Tudor Lodge, 125A Sea Road, East Preston, BN16 1NX

**Submission of REVISED details pursuant to condition 6 of consent
APP/C3810/W/17/3183667 [LPA Ref: EP/59/17/PL]**

Cross section: Evolve VS windows

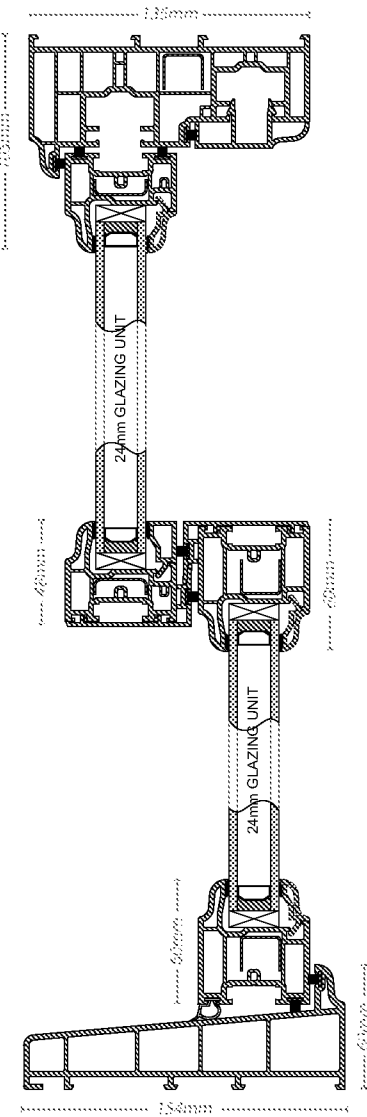
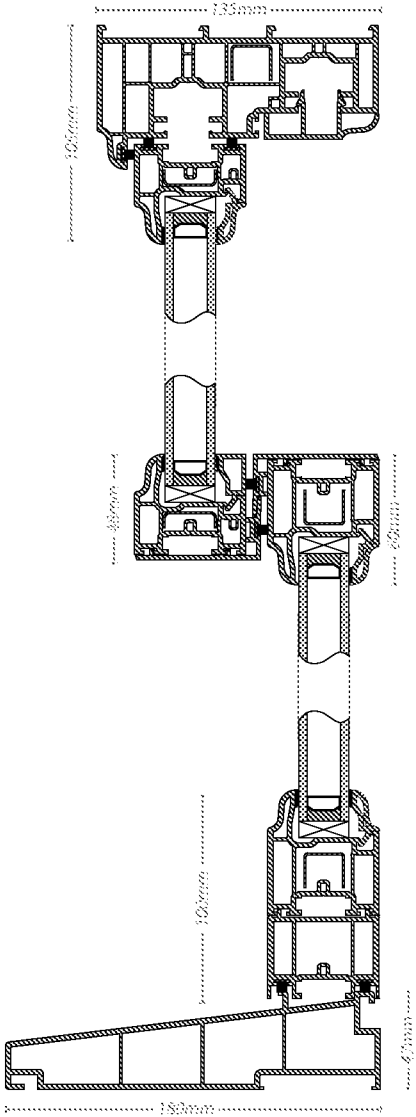
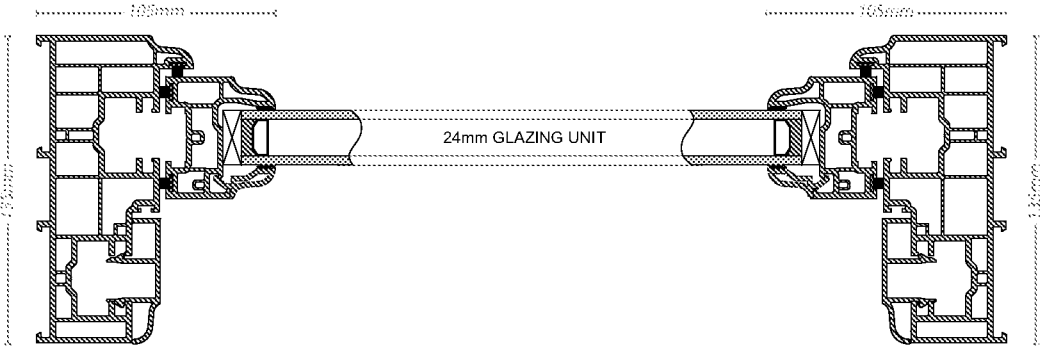
The revisions relate solely to the windows, which are now proposed to be Evolve UPVC Traditional Sash Window with centre bar [see page 10 of attached document], in place of Bereco Timber Windows. We have been advised that given the coastal location and damaging salty air, UPVC windows would have greater longevity than the timber window first suggested.
